Our reference: SF/16/21988, DOC17/318993

**ToxFree Australia Pty Ltd - 40 Christie Street St Marys
Modification of an Existing Activity MOD06_0095 MOD4.**

I refer to your correspondence dated 24 May 2017 and the attached documents, which included "Proposal for the acceptance and treatment of E-waste & Minor Site Works ToxFree Australia Pty Ltd, Environmental Assessment: MP06_0095MOD 4, May 2017"; a site plan; "Noise Assessment – Toxfree Treatment Facility Upgrade, St Marys prepared by Wild Environment dated 4 April 2017"; "Mass Balance Flat Plan Displays"; and "Manufacturer specification of Blue Box".

13 June 2017

Figure 5.3.4: On-site Noise Monitoring Locations

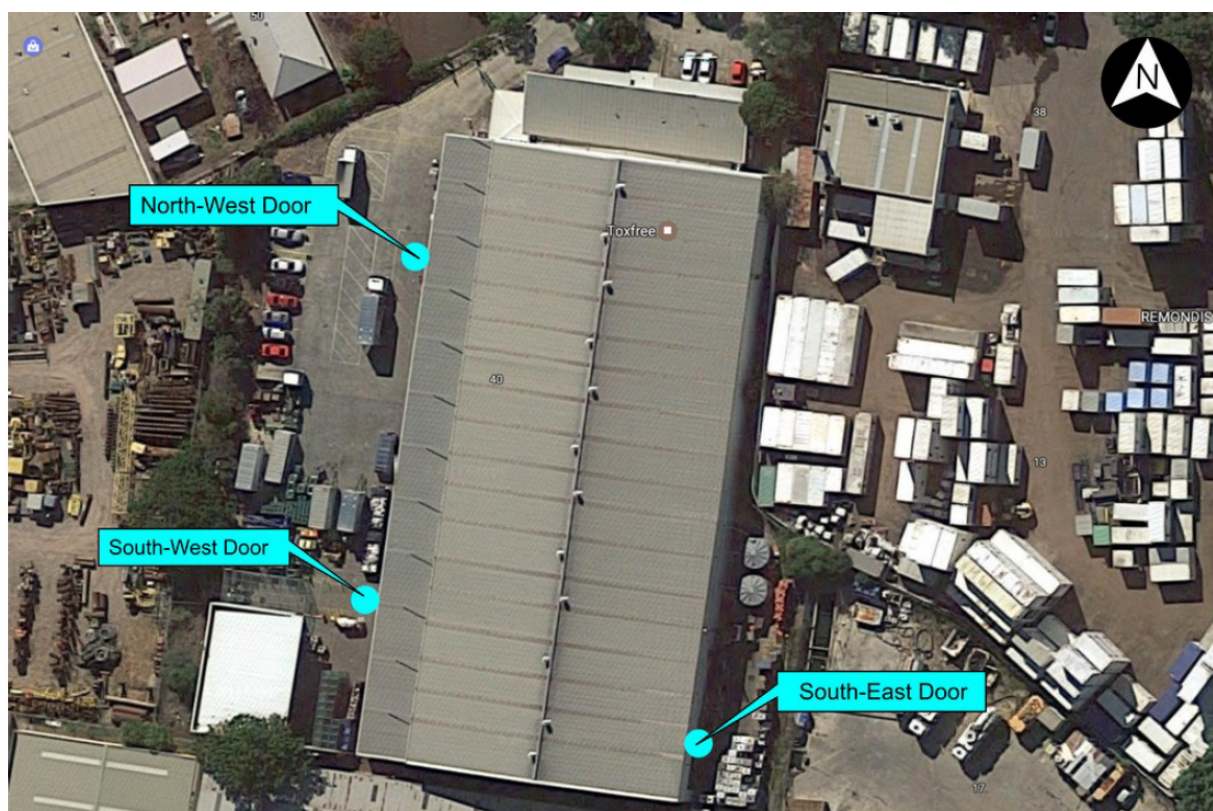
The EPA note that the noise assessment shows a total of four roller doors on the treatment building. Modelling has been carried out assuming these doors are open. To provide additional noise mitigation to nearby residences, the EPA recommend that these doors, and particularly the eastern side door facing residences, be kept closed or fitted with fast opening/closing shutters to be operated from 5am to 7am and 10pm to 11pm where practicable, subject to safety and operational considerations.
